30 June 2017

**Hume Coal Project (SSD 7172) and Berrima Rail Project (SSD 7171)**

I refer to your e-mail dated 31 March 2017 inviting WaterNSW to make a submission, including recommendations, on the Environmental Impact Statements (EIS) for the Hume Coal Project and related Berrima Rail Project. WaterNSW's primary concerns with the EISs are listed below, with more detailed comments provided in the attachments.

A water balance schematic representing the inputs to GoldSim is presented in Figure 7.4.

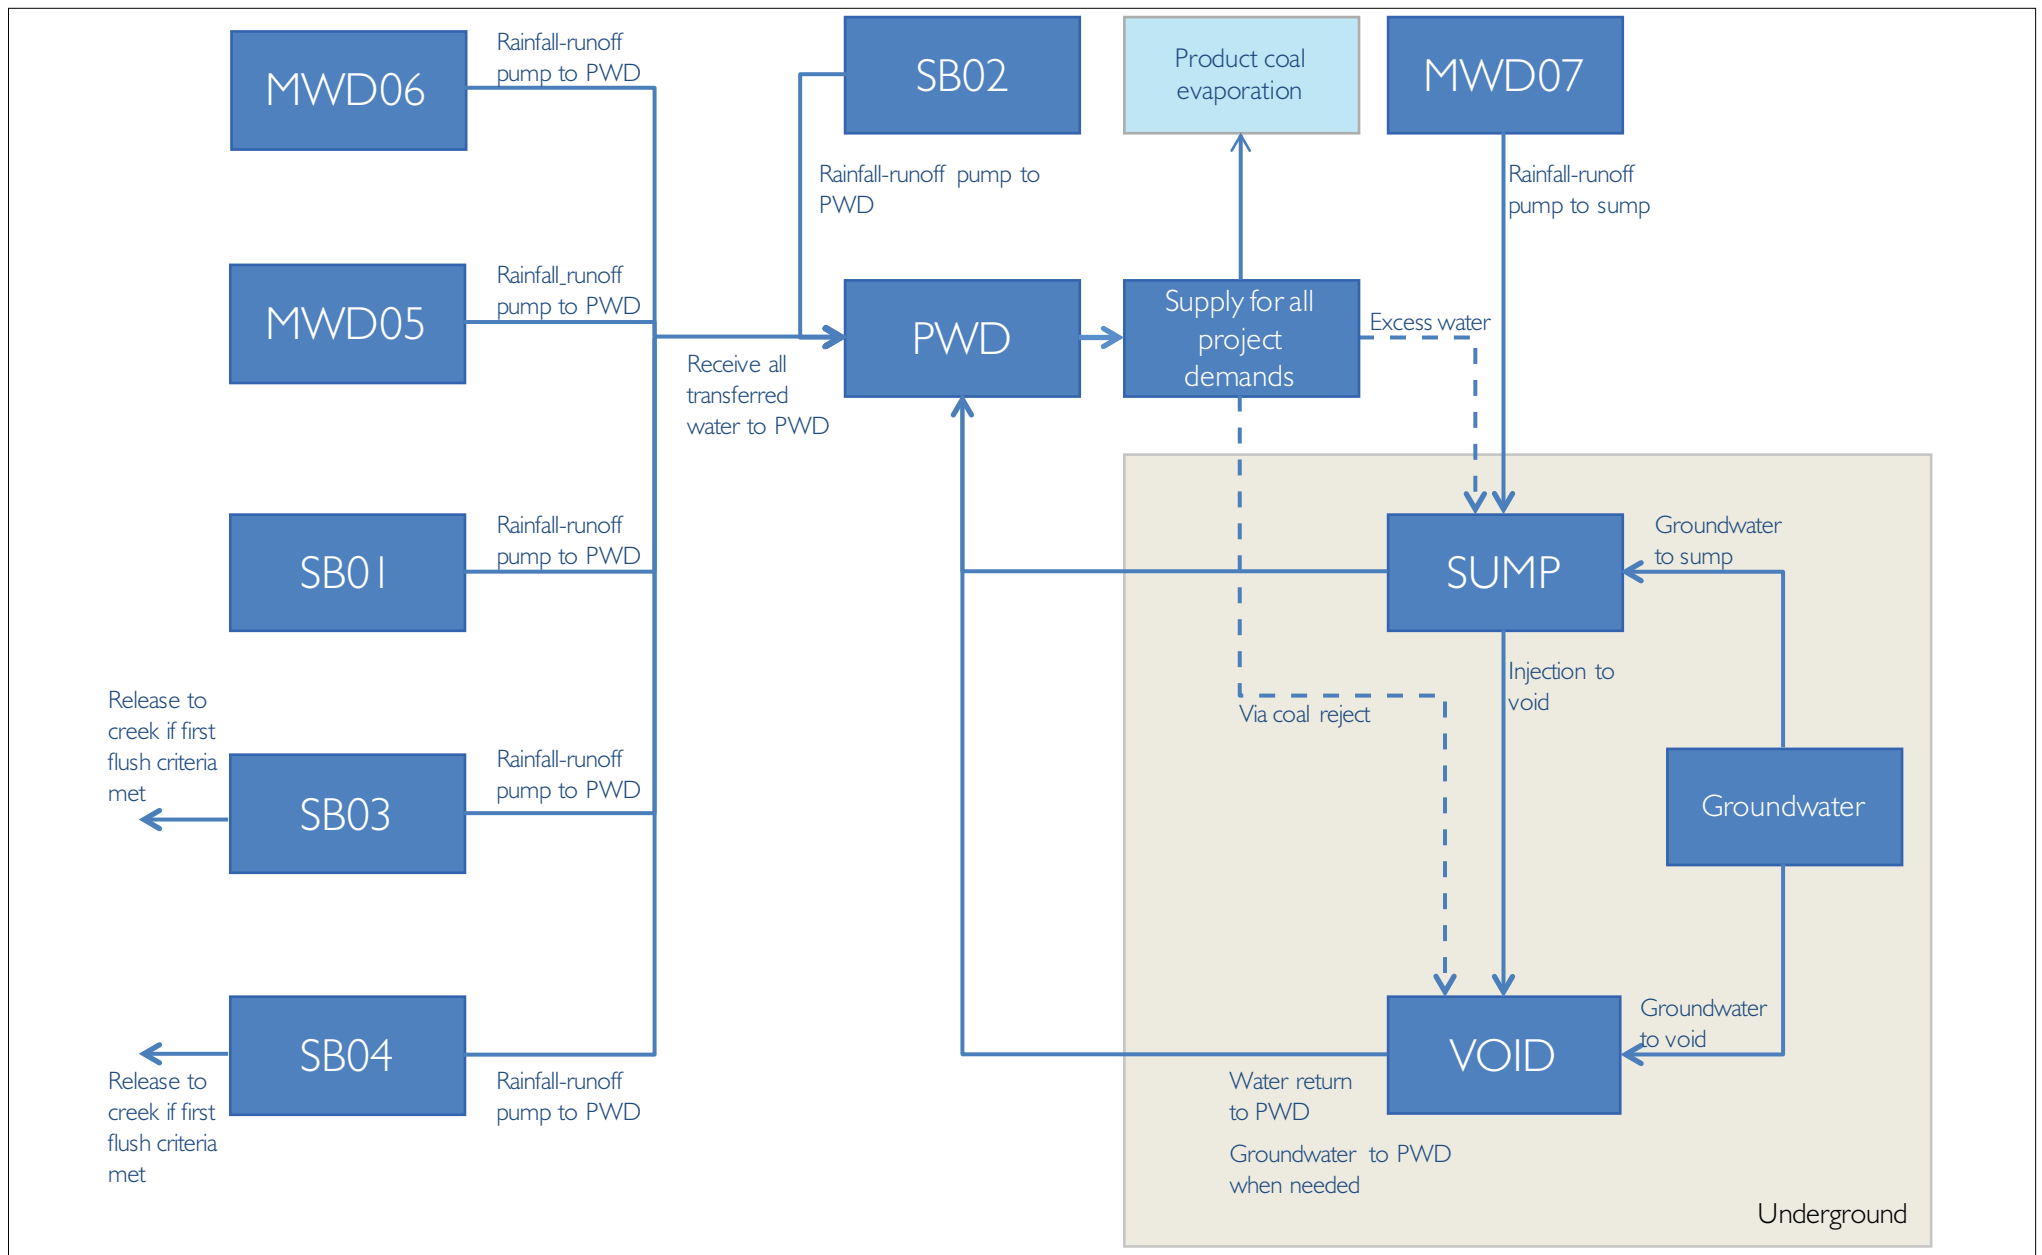
The mine inputs and outputs in the groundwater assessment in Volume 4b, Appendix I, Table 6 are inconsistent and appear to contradict the average annual water balance inputs and outputs in Volume 4a, Figure 8.2. Table 6 shows the mine operation is likely to experience net water deficit for 15 out of the 19 years of modelled mine operation whilst Figure 8.2 shows the mine will have net water balance on an average annual year. **This is a significant concern to WaterNSW and needs to be addressed prior to the Department’s assessment of the Project.**
